Application for Non-material Amendment to Reserved Matters Approval ref. 15238/23

Plot 3, Wingates Industrial Estate, Great Bank Road

Panattoni are seeking to make non-material amendments to Reserved Matters Approval ref. 15238/23 [the RMA] in respect of an additional substation, increased provision of solar photovoltaic panels and other minor changes to external design. This necessitates the substitution of drawings and associated changes to the wording of conditions 2 (approved plans), 5 (car parking spaces), 7 (access), 9 (landscape scheme) and 14 (external lighting) attached to the RMA.

Title **UNIT 3 EXTERNAL LIGHTING
& LUX PLOT LAYOUT**

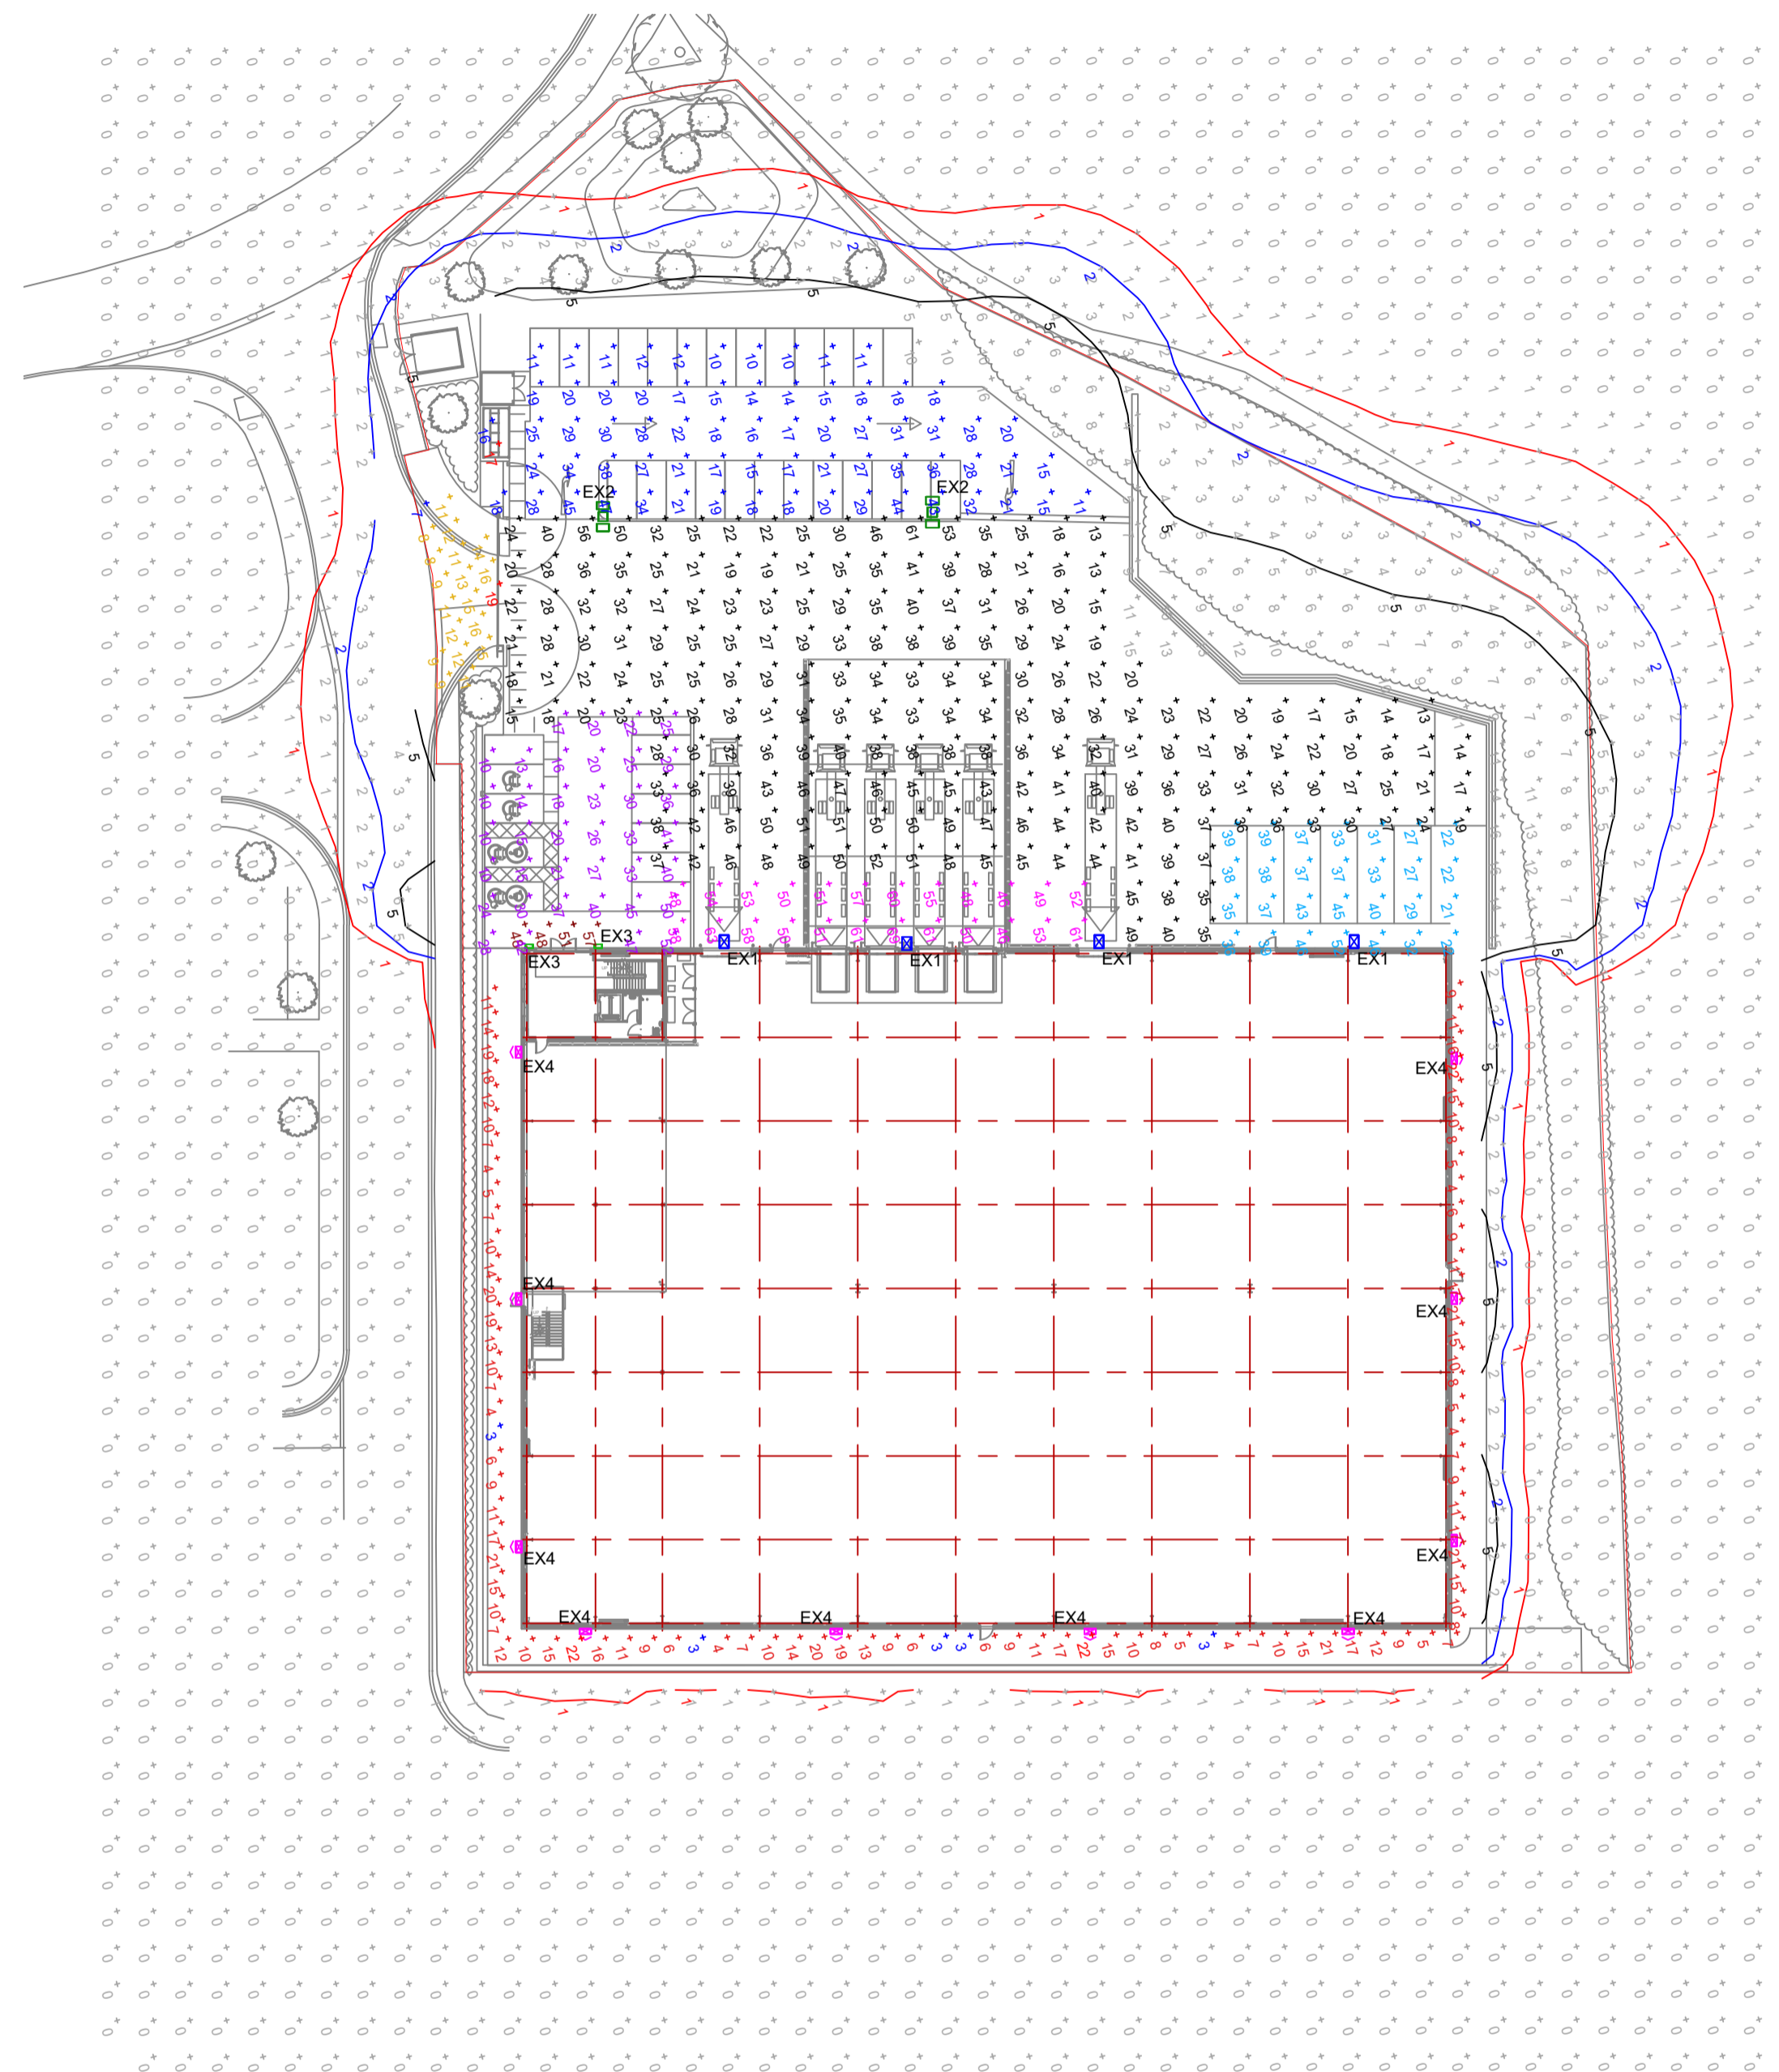
With regards to the external lighting of the main entrance, the two proposed wall mounted fixtures (EX3) will project from the western elevation of Unit 3 and will illuminate the ground below. Please refer to a comparison of the approved and proposed lighting plans in Figure 1 below. The levels of illumination are detailed on the Unit 3 External Lighting and Lux Plot Layout Plan, a snippet of which is used in Figure 1 (ref. P23012-EBM-EX-XX-DR-E-0931 rev. P2). This demonstrates the illumination

level of the proposed projecting light fixtures will be lower than the level of illumination of the lighting bollards. The illumination levels of the approved lighting bollards can be found on the Proposed External Lighting Layout which was submitted with the RMA (ref. 220512 rev. P01). The level of illumination will remain sufficient for users of the site during times of darkness. The proposed lighting fixtures will therefore reduce light emissions. The proposed projecting light fixtures are also considered to frame the entrance to the building, offering an improved way finding function for visitors, and negate the need for bollards in the public realm areas. On this basis it is considered that the wall mounted light fixtures will not result in adverse amenity impacts for the residents located to the north of the site on Wingates Grove but will continue to serve their purpose by illuminating the main entrance. This change is clearly non-material.

*“External lighting / floodlighting shall be installed as set out in the **following plans: Unit 3 External Lighting & LUX Plot Layout ref. P23012-EBM-EX-XX-DR-E-0931 rev. P2 and Unit 3 External Lighting Elevation ref. P23012-EBM-EX-XX-DR-E-0933 rev. P1.** external lighting report submitted with the application, Wingates Plot 3, by CPWP, reference 220512 Rev P01, dated 18/11/22. The lighting shall be designed to an illumination value of no more than 5 lux at the nearest residential property. The beam angle of any lights directed towards any potential observer should be kept below 70 degrees. Spill shields should also be fitted (if necessary). The approved scheme shall be implemented in full before the development is first brought into use and retained thereafter.”*

DRAWING
DETAILED PLANTING PLAN

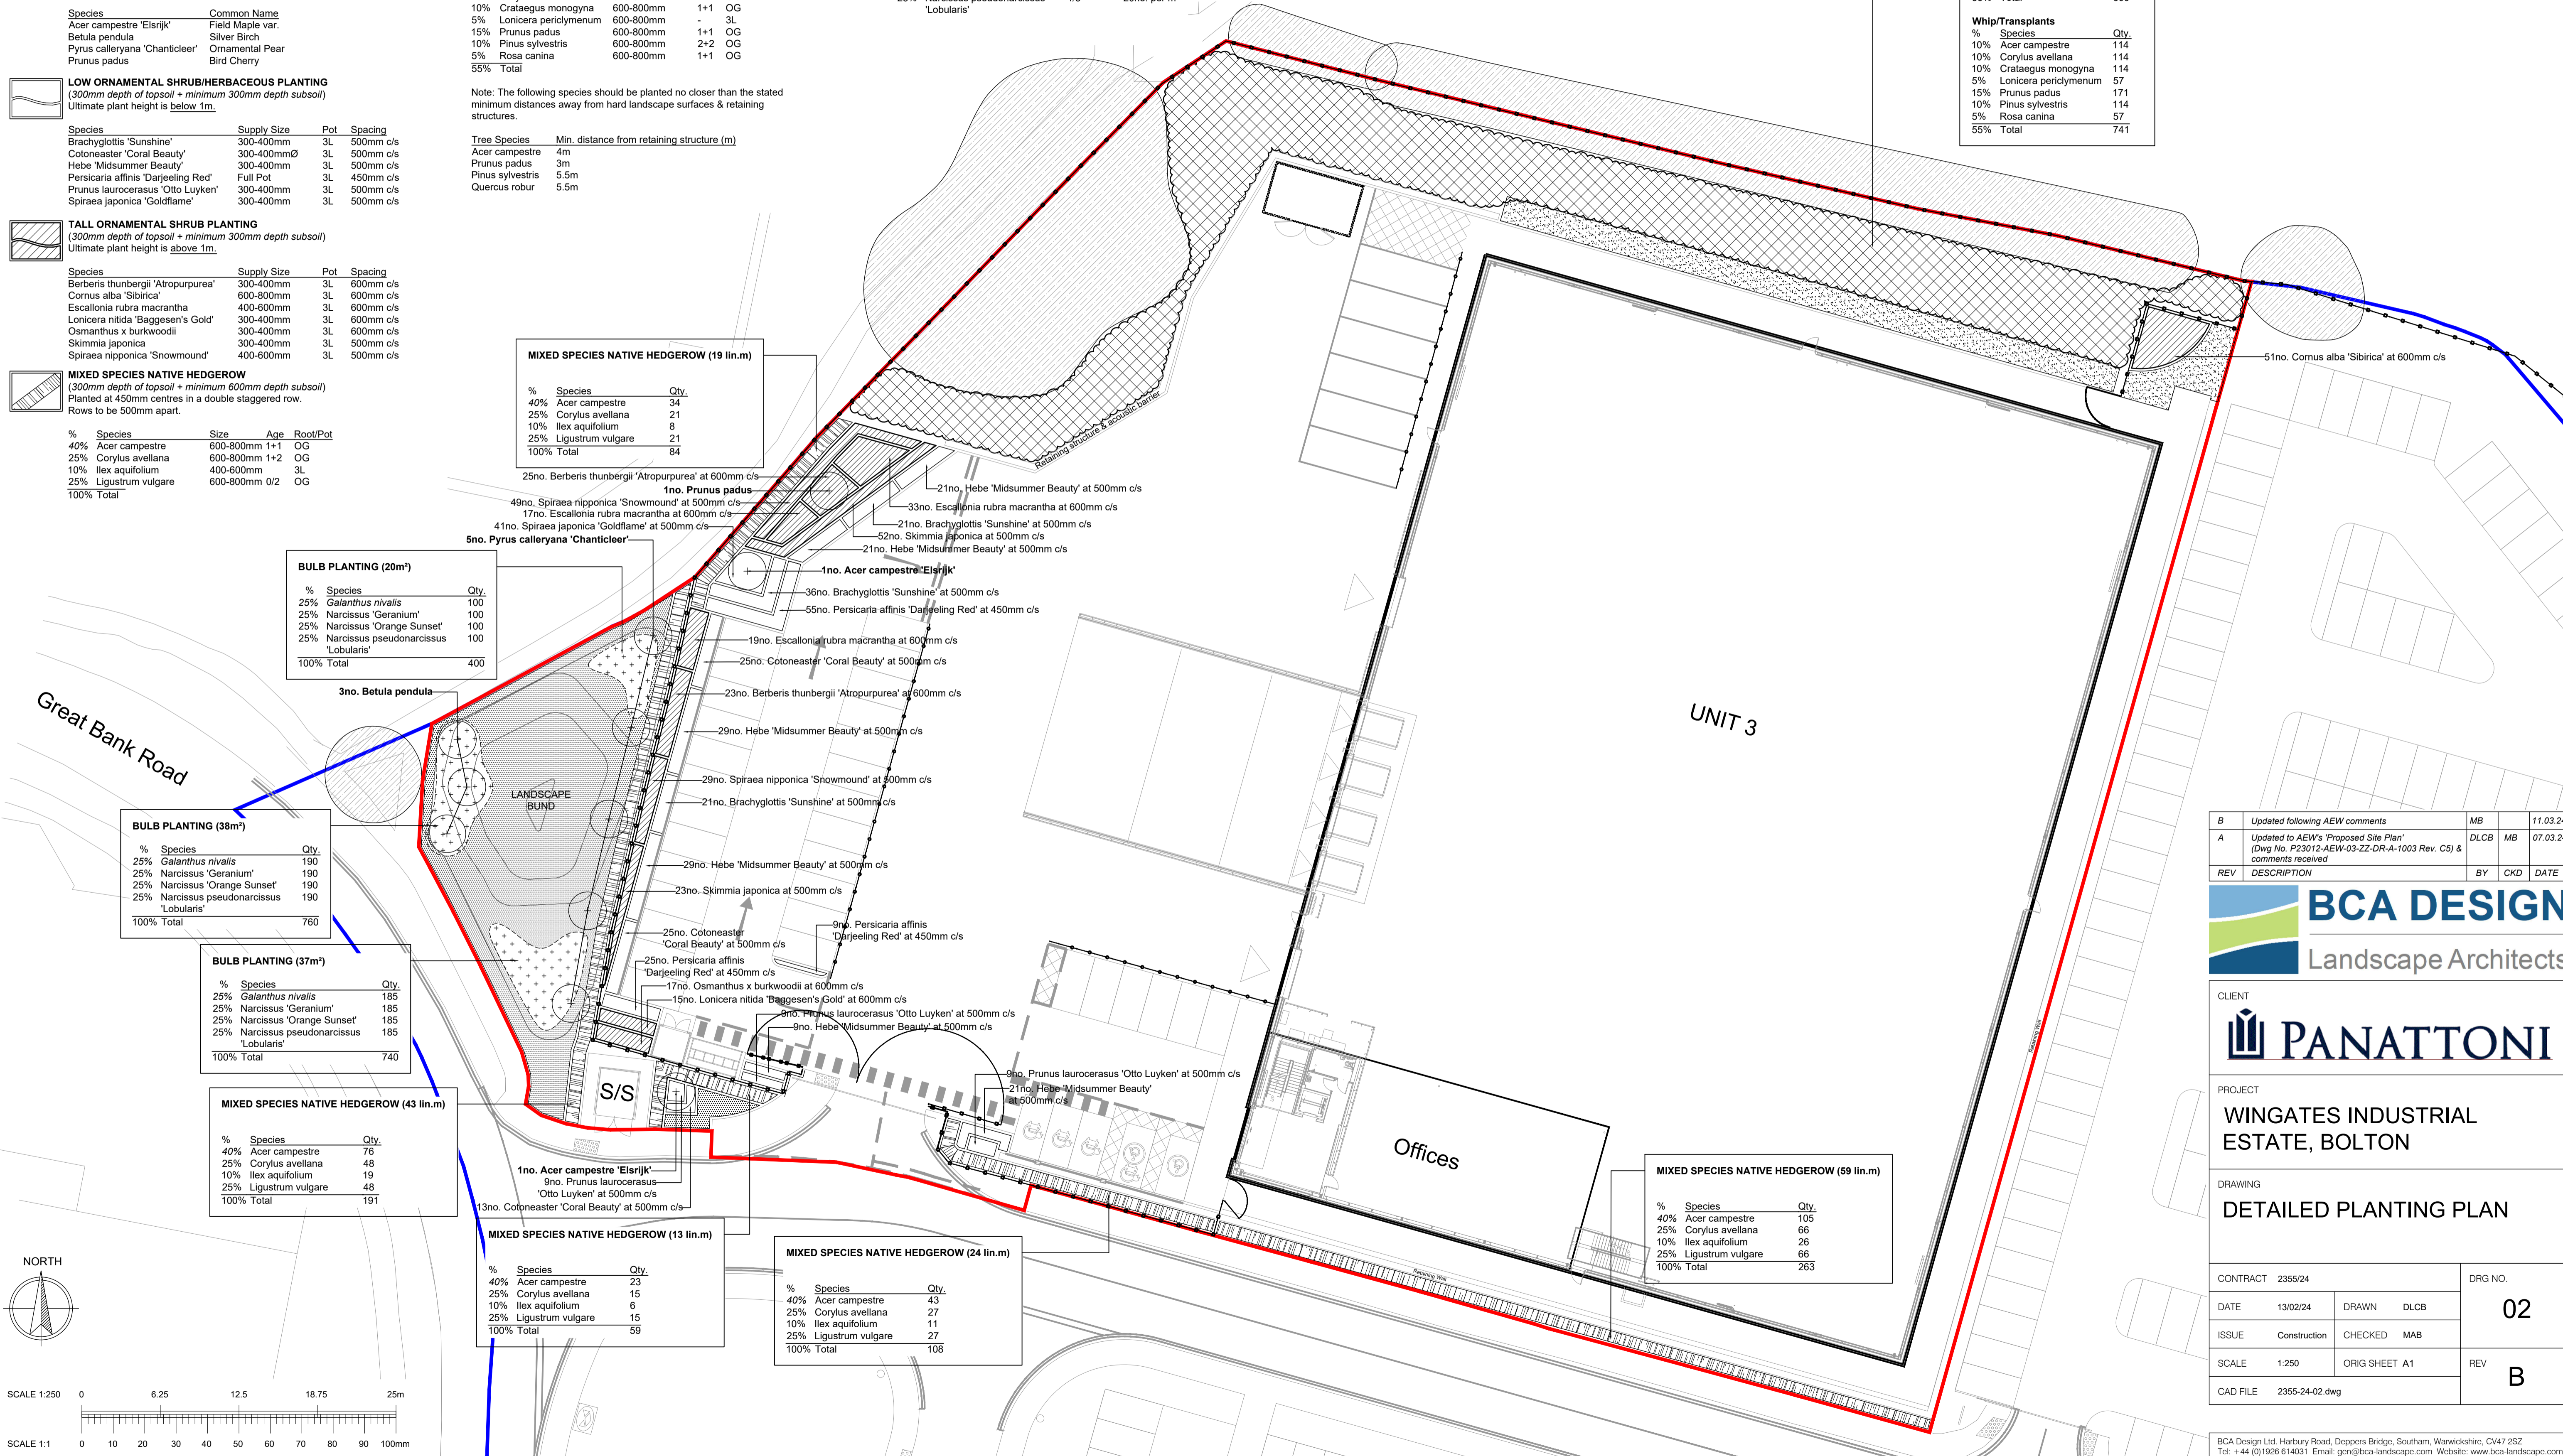
There will be no impact on biodiversity or ecology as a result of the small reduction in grassed area.

“The approved landscape scheme as shown on: Detailed Planting Plan drawing no. 02 rev. B ~~Soft Landscape Section Elevations, drawing no. 12176_P11 and Soft Landscaping Proposals — Sheet 2 of 2 drawing number 12176_P10 rev.C~~ shall be implemented in full within the first planting season following completion. Any trees and shrubs that die or are removed within five years of planting shall be replaced in the next available planting season with others of similar size and species.”
